ALTUS PAGE KIRKLAND

CAMPBELL'S STORES

DA ACCESS REVIEW

26 October 2015

Drawing Title  
**SITE PLAN**  
**PROPOSED**  
 JPW Project Number  
**12006**  
 Drawing Status  
**EA**  
 Drawing Number  
**EA-A-002**  
 Revision  
**B**

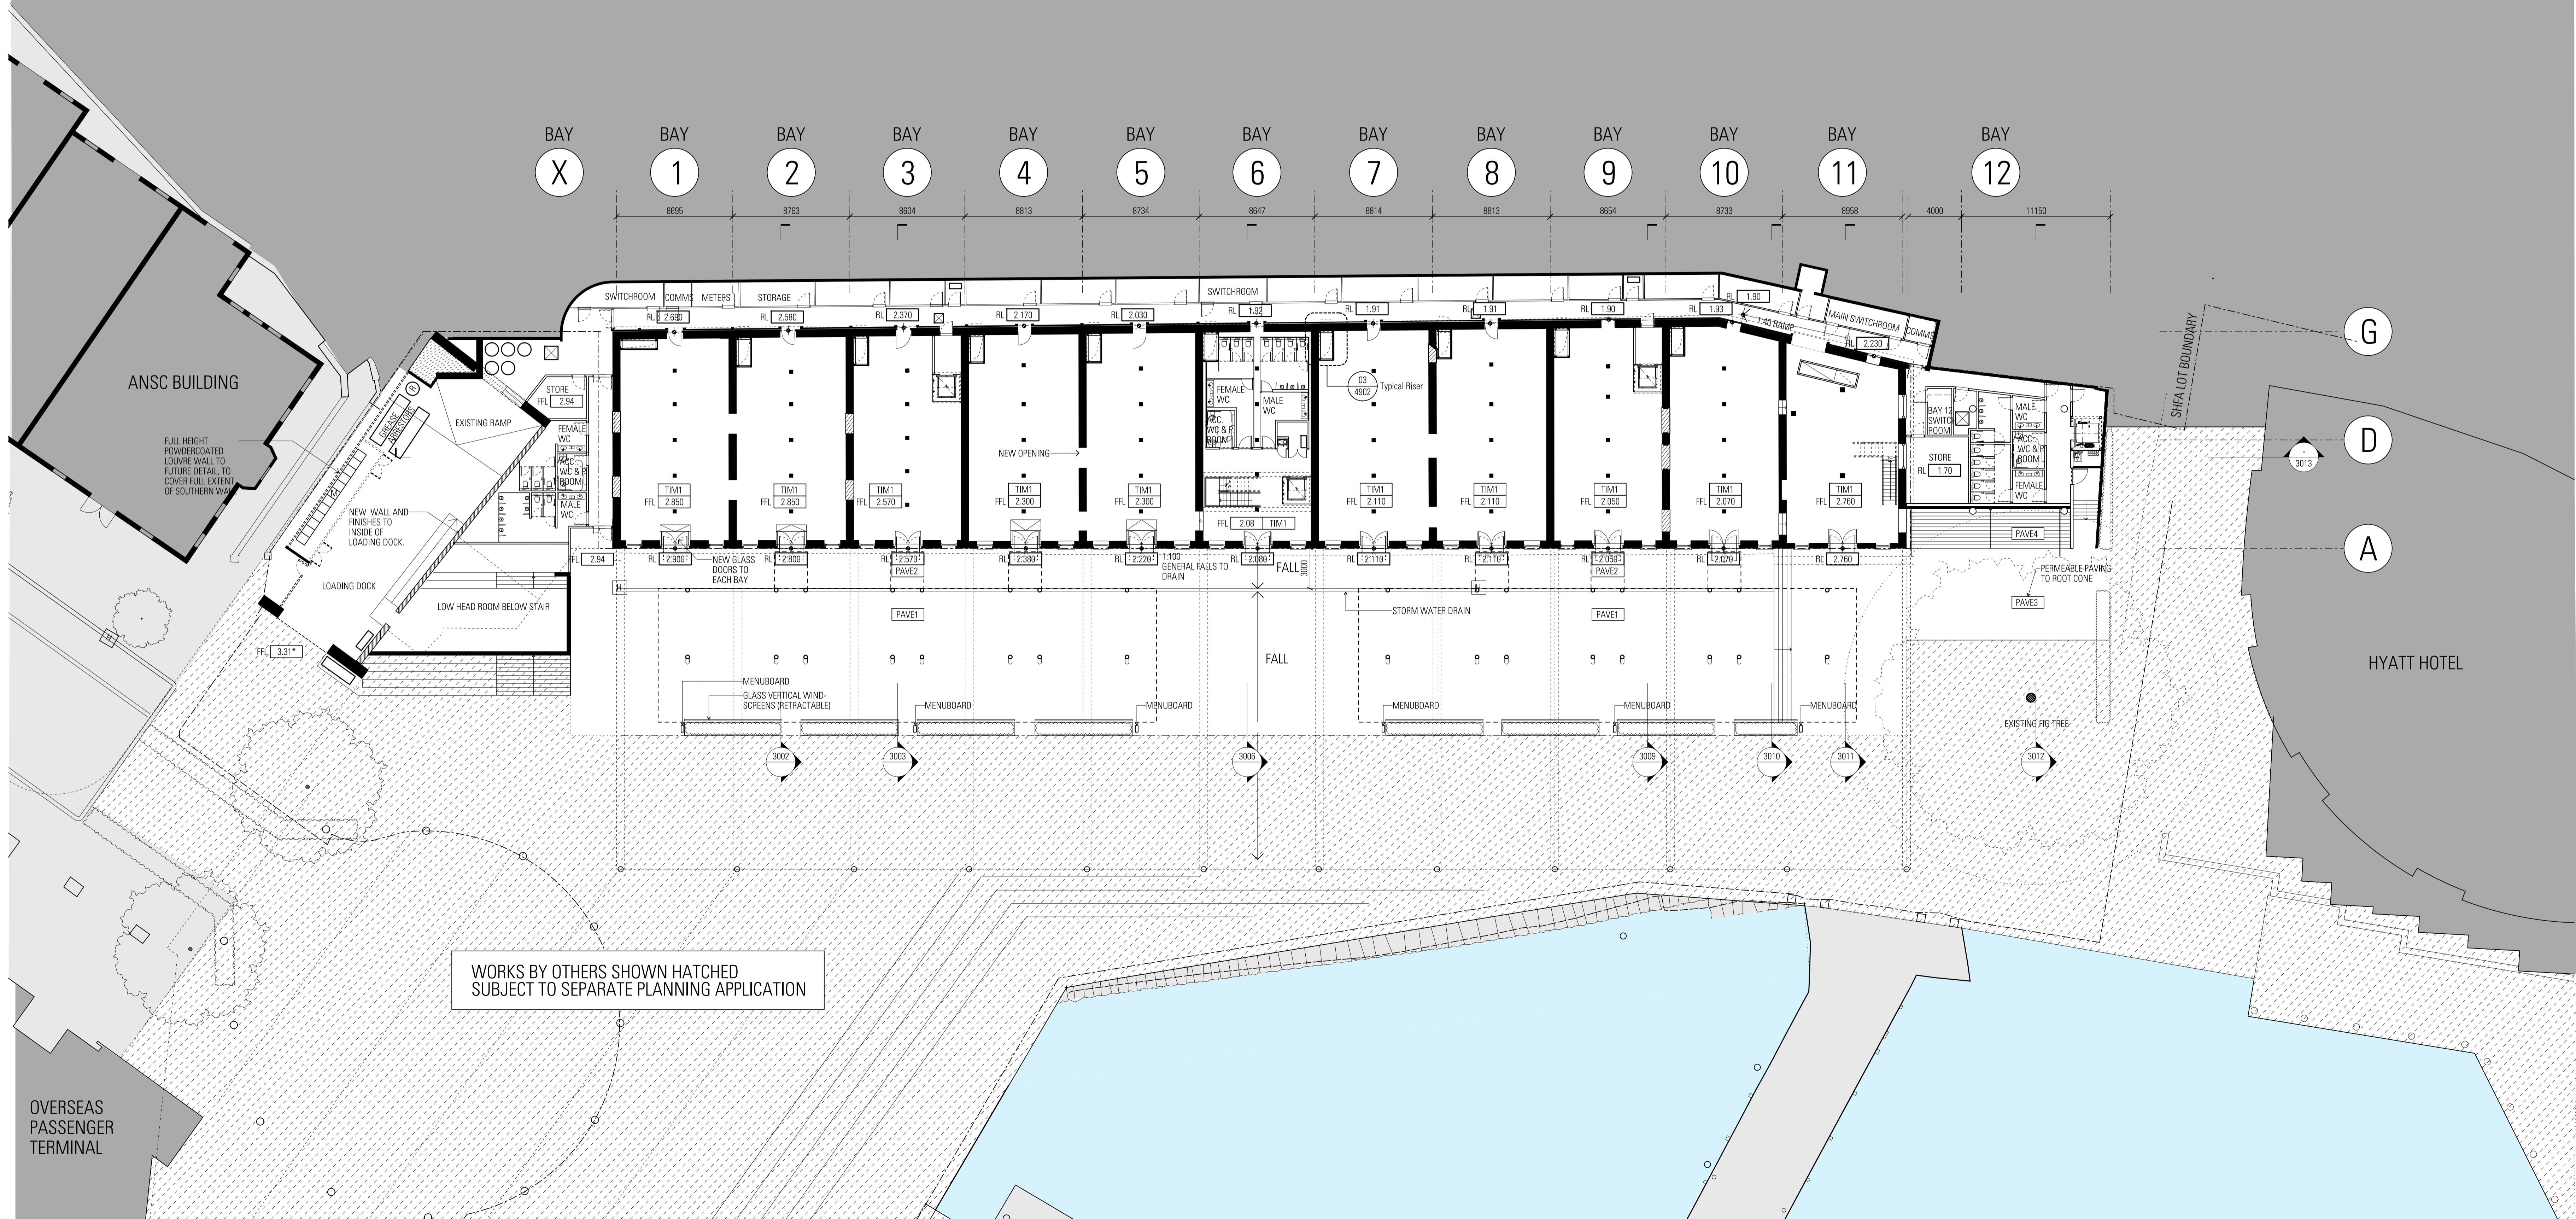
A new raised pedestrian crossing is indicated on western side of building opposite bay 5/6 with new kerbs proposed to provide improved pedestrian traffic and safety. Review will be required of the proposed surface to ensure accessibility for people with disabilities, compliant with AS1428.1.

- (i) Provide new stairways with stair configuration and handrails on both sides of the stair, compliant with AS1428.1:2009. Note: stairs to be recessed by 900mm at base on site boundary so that handrail extensions and TGSIs are not located on public footpath/transverse paths of travel.
- (ii) Ensure new pedestrian crossing and connecting footpath linkages to accessible building entrances on Hickson Road are accessible to people with disabilities, compliant with AS1428.1. Note: cobble paving surfaces are not generally compliant with AS1428.1 due to uneven surface profile variations.

There is an existing steep/moderate and inconsistent graded ramp/partial service road at northern façade that connects Hickson Road with Circular Quay that is step free but is not compliant with AS1428.1:2009. This area is discussed further in Section 7.1.
